**WELWYN HATFIELD COUNCIL – DEVELOPMENT CONTROL**  
**DELEGATED REPORT**

<b>APPLICATION No:</b>	<b>S6/2011/1999/LU</b>
----------------------------	------------------------

**DESCRIPTION OF PROPOSAL:**

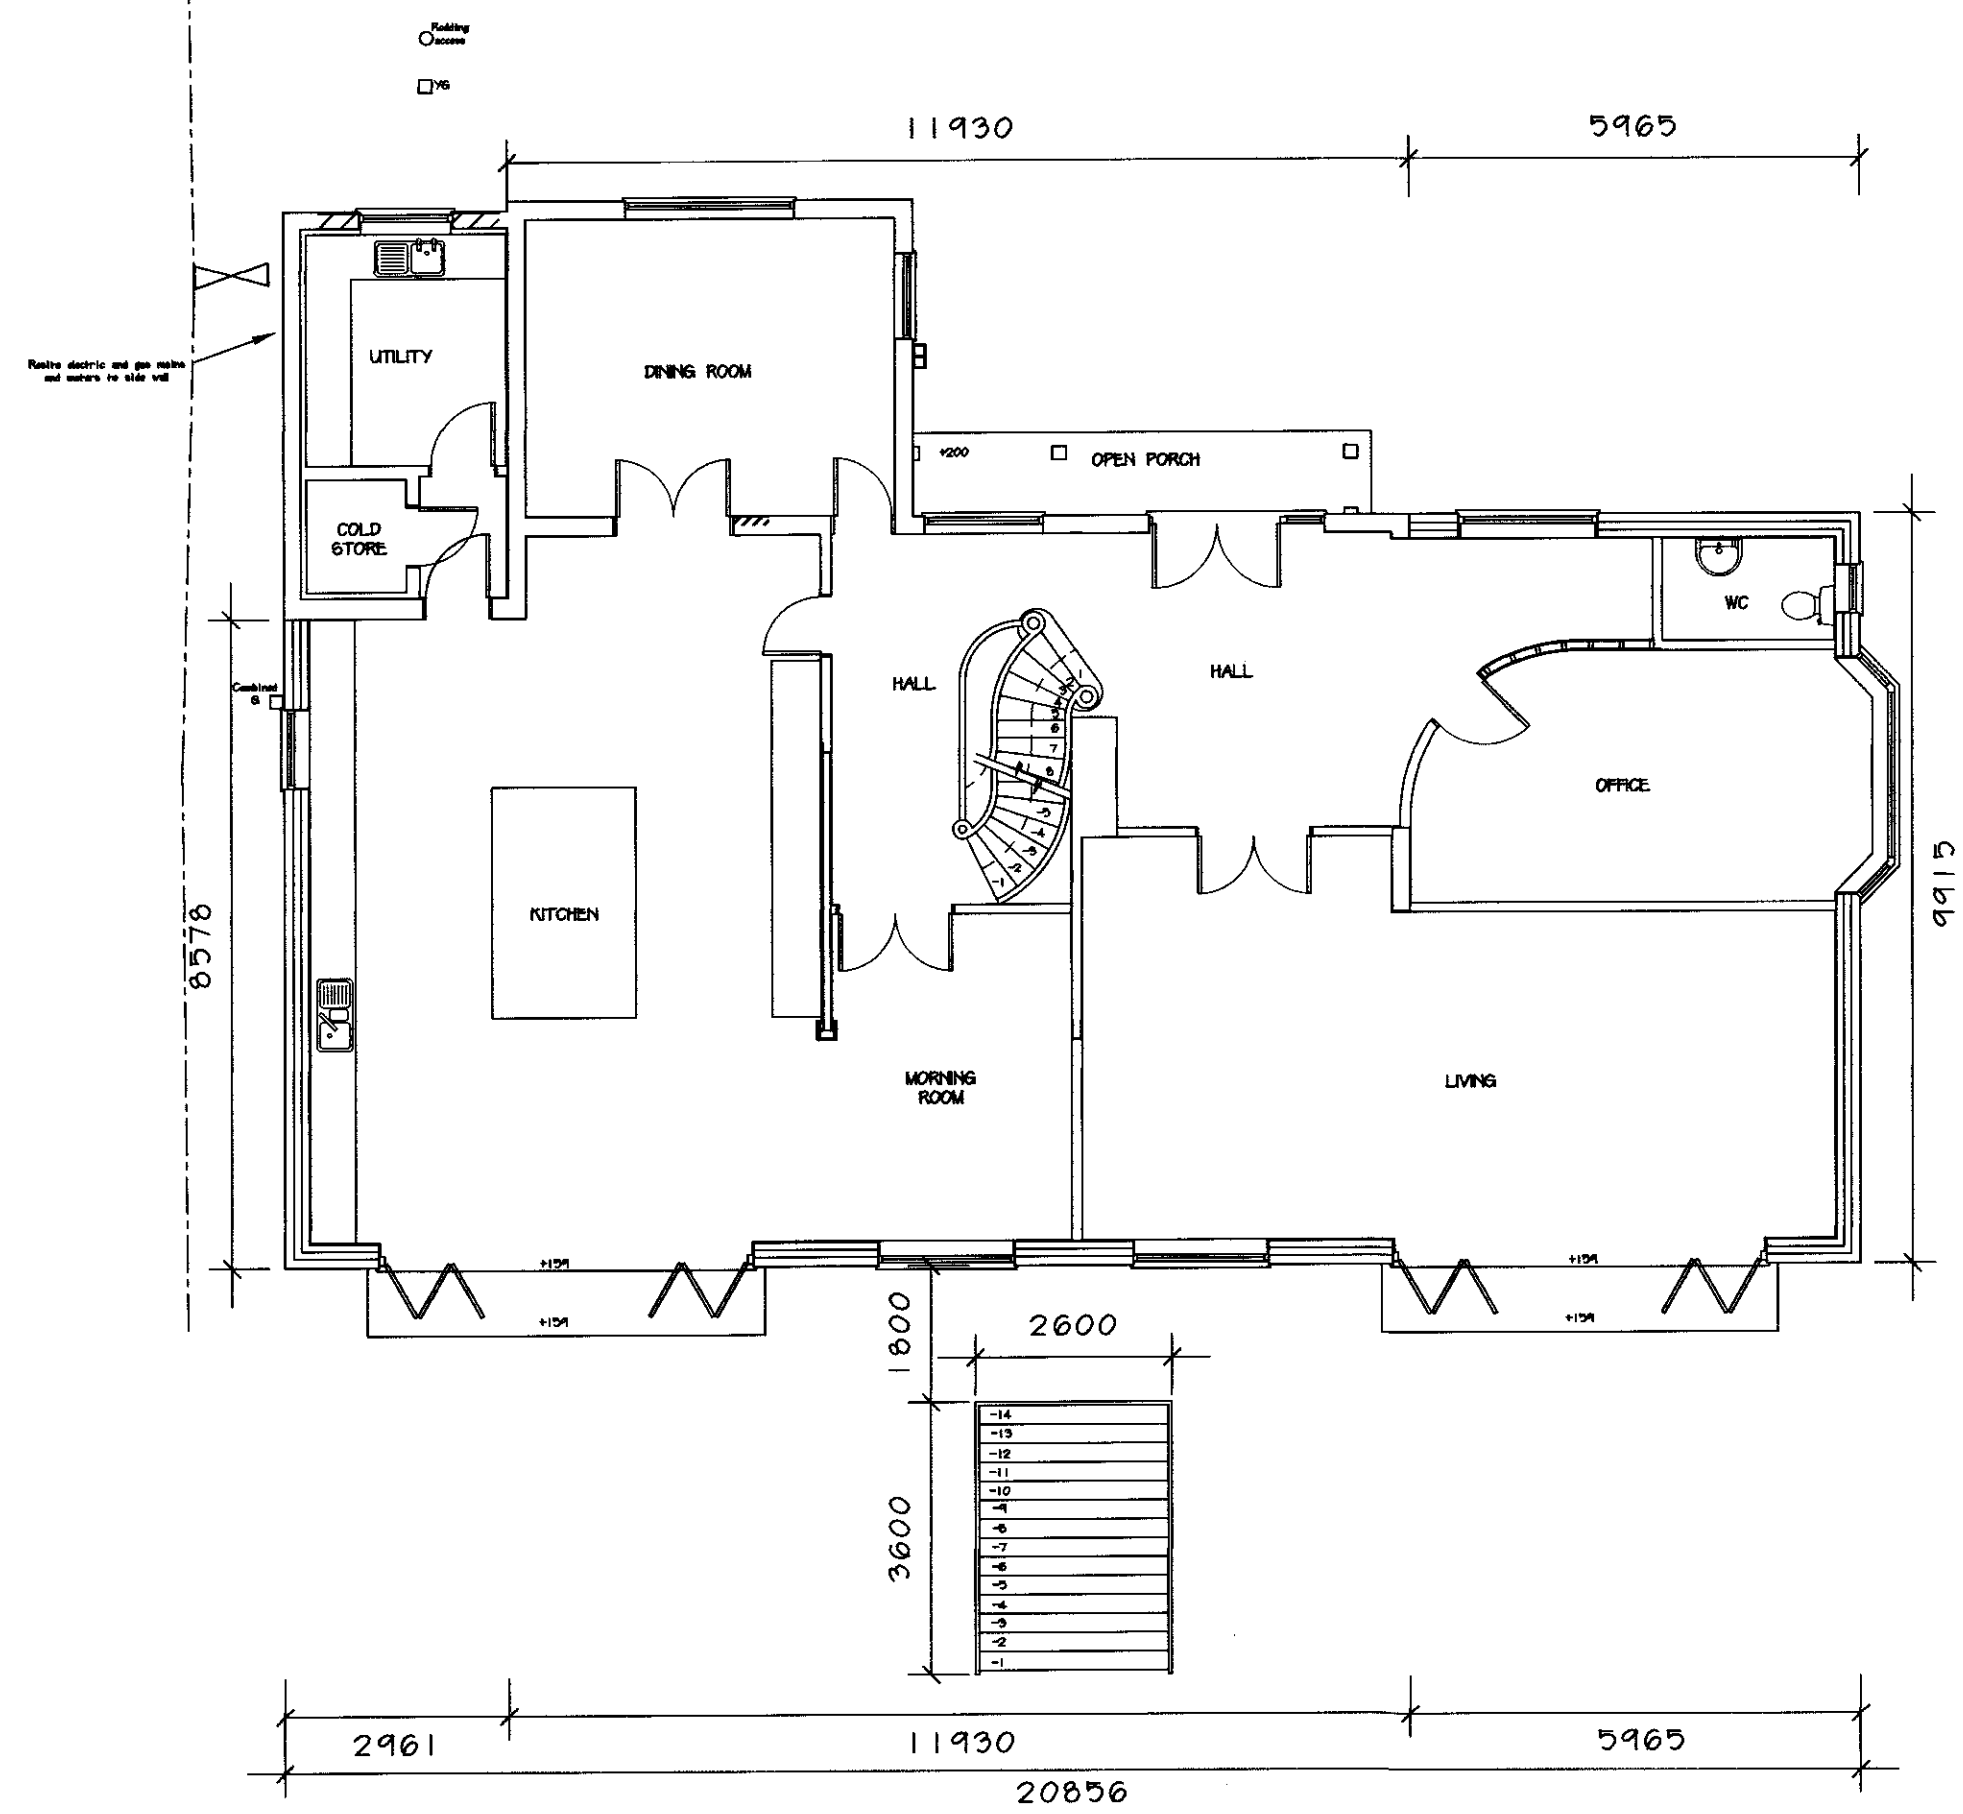
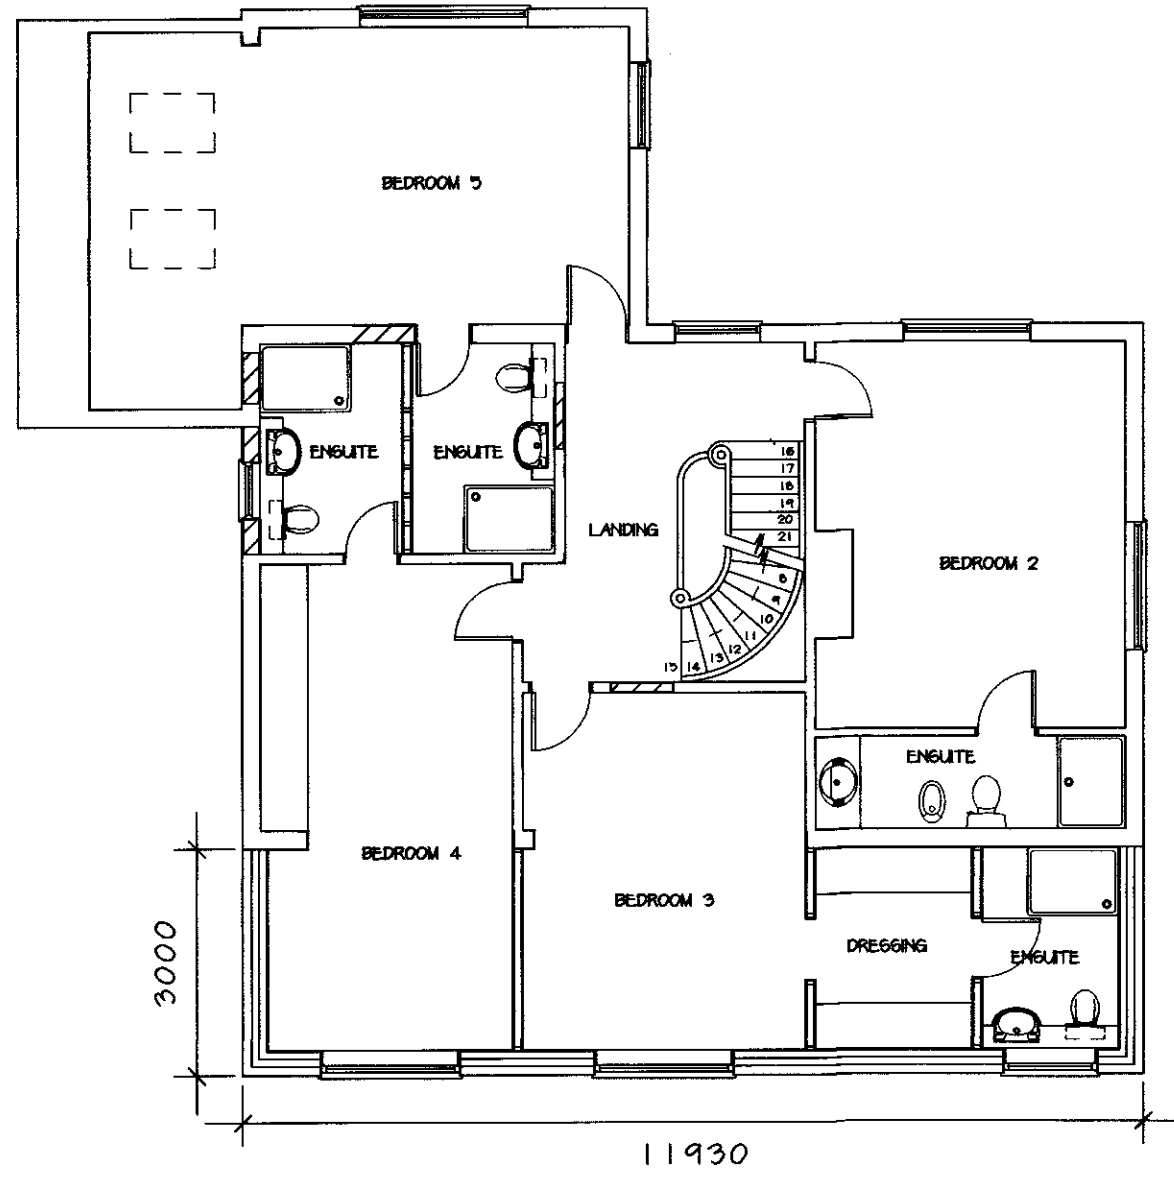
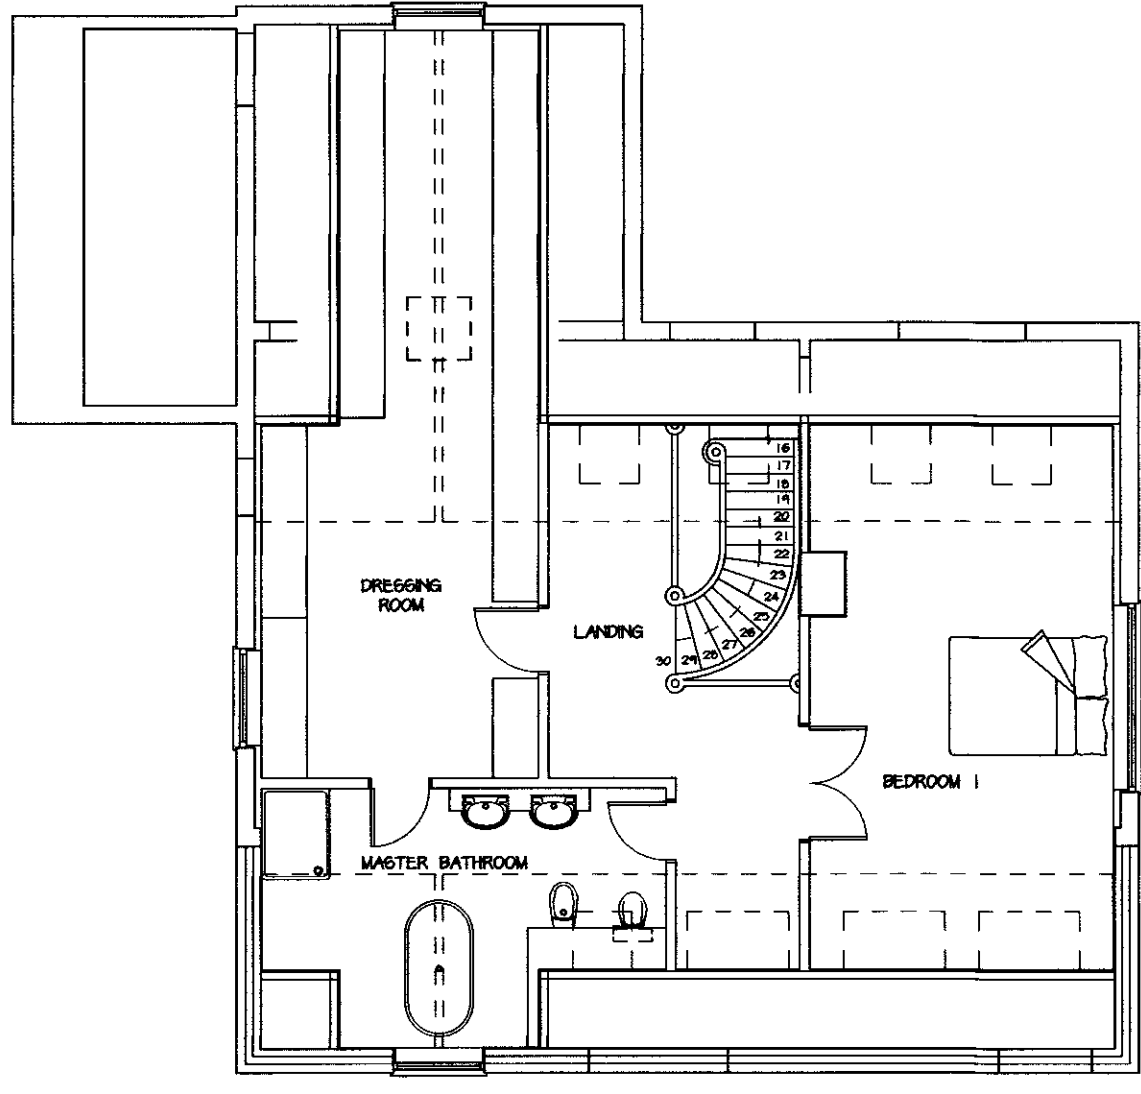
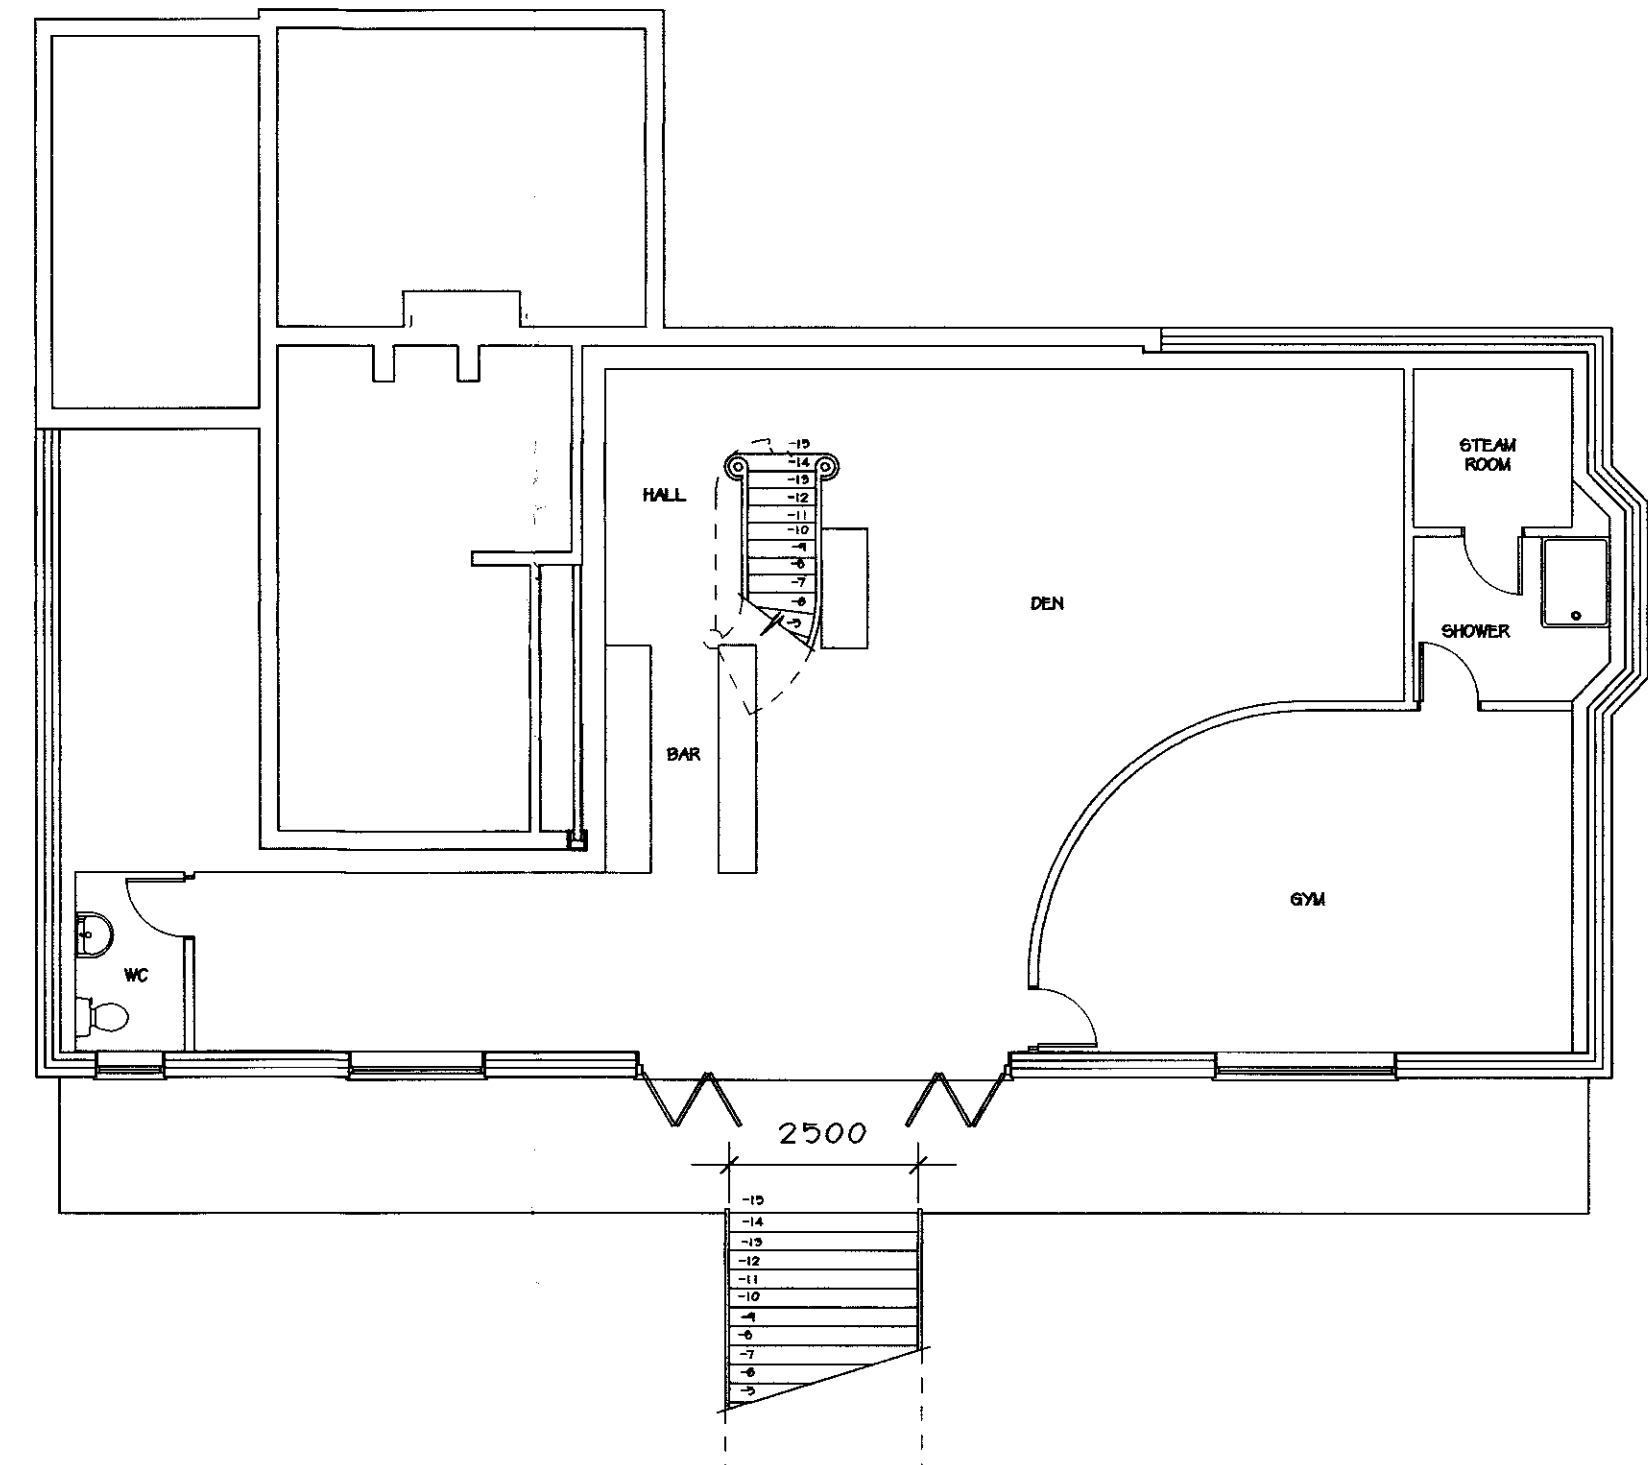
*The existing utility room is to be demolished as part of the proposal and therefore the proposed extension on the north eastern side elevation in combination with the basement measures 8.5m from the rear wall of the existing garage (original dwelling) which fails to comply with part (f) (i)*

*The proposed extension on the south western side elevation in combination with the proposed basement measures 6.5m from the side elevation of the existing dwellinghouse and would exceed 4m in height.*

*The proposed side extension would also have a width greater than half the width of the original dwellinghouse when considered in combination with the proposed rear extension which will effectively create a 'wrap around' extension both at basement and ground floor level. Page 26 of the Technical Guidance referenced above under part (e) shows examples where an extension fills the area between a side elevation and a rear wall. In this instance, part of the side extension connects with the proposed rear extension. The rear extension when combined with the proposed side extension will extend more than half the width of the existing dwellinghouse.*

*The proposal therefore fails to comply with Class B (c) by virtue of the additional volume of the roofspace exceeding 50m<sup>3</sup> upon the roofspace of the original dwelling*

- Class A (f) by virtue of the proposed extension on the north eastern side elevation in combination with the basement is more than one storey in height and measures more than 4 metres from the rear wall of the existing garage (original dwelling),

- Class A (h) by virtue of the proposed side extension in combination with the basement being more than 4 metres in height, having more than one storey and the proposed side extension having a width greater than half the width of the original dwellinghouse when considered in combination with the proposed rear extension which will effectively create a 'wrap around' extension,

- Class B (c) by virtue of the additional volume of the roofspace exceeding 50m<sup>3</sup> upon the roofspace of the original dwelling,
2. Evidence has not been put before me which suggests that the parcel of land to the rear which accommodates the stable block, as outlined in red on the Site Location Plan (1:1250), can be considered as part of the residential curtilage. Whilst the stables have appeared to cease use, the two parcels of land in question remain defined by existing boundary treatments and it is considered that the parcel of land to the rear does not constitute part of the residential curtilage. Therefore, the proposed extension and conversion of the existing stable block to a double garage cannot be considered under permitted development.
